WEST SUSSEX COUNTY COUNCIL CONSULTATION

TO:	Arun District Council FAO: Mr Z Denton
FROM:	WSCC - Highways Authority
DATE:	28 November 2019
LOCATION:	Silo at Former McIntyre Nursery Littlehampton Road Ferring BN12 6PG
SUBJECT:	FG/135/19/PL Demolition of a Silo & erection of an office building (B1(a) Business), 6 No. parking spaces for office workers & erection of boundary fencing.
DATE OF SITE VISIT:	n/a
RECOMMENDATION:	Advice
S106 CONTRIBUTION TOTAL:	n/a

3 Site
1 : 200

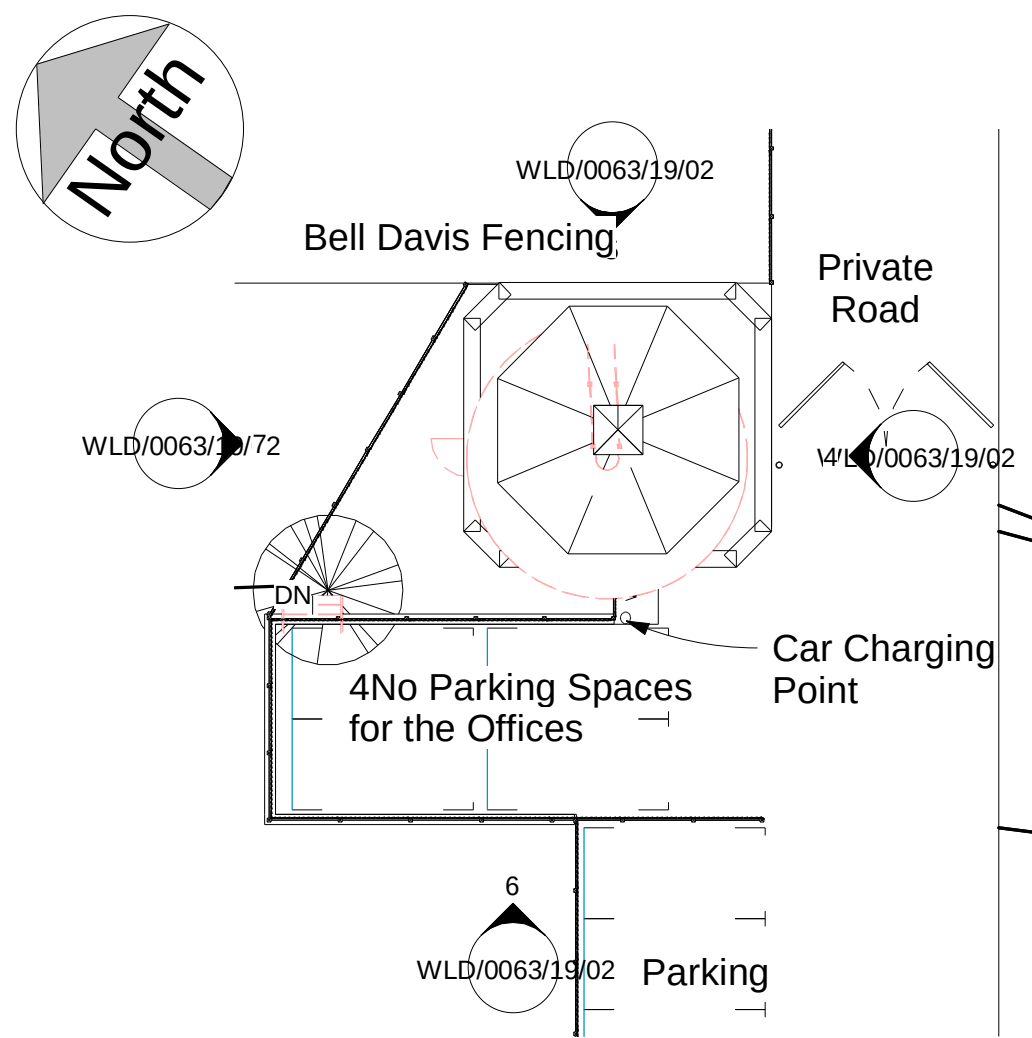
The application documents state that 6 spaces will be provided; this would meet the anticipated demand. The actual vehicular parking spaces have not been demonstrated in any detail. I'm minded to accept that spaces can be accommodated within land under the applicants control without impacting the maintained network. I would therefore be minded to advise that the Local Planning Authority be satisfied that the spaces can be provided and secured via planning permission. Any spaces should measure a minimum of 2.4 x 4.8 metres and be afforded the opportunity to turn on site. This may require amendments to the red red edge plan.

If the LPA are minded to grant planning consent a condition securing vehicle parking would be advised:

Car parking space

No part of the development shall be first occupied until the car parking spaces have been constructed in accordance with plans and details submitted to and approved in writing by the Local Planning Authority. These spaces shall thereafter be retained at all times for their designated use.
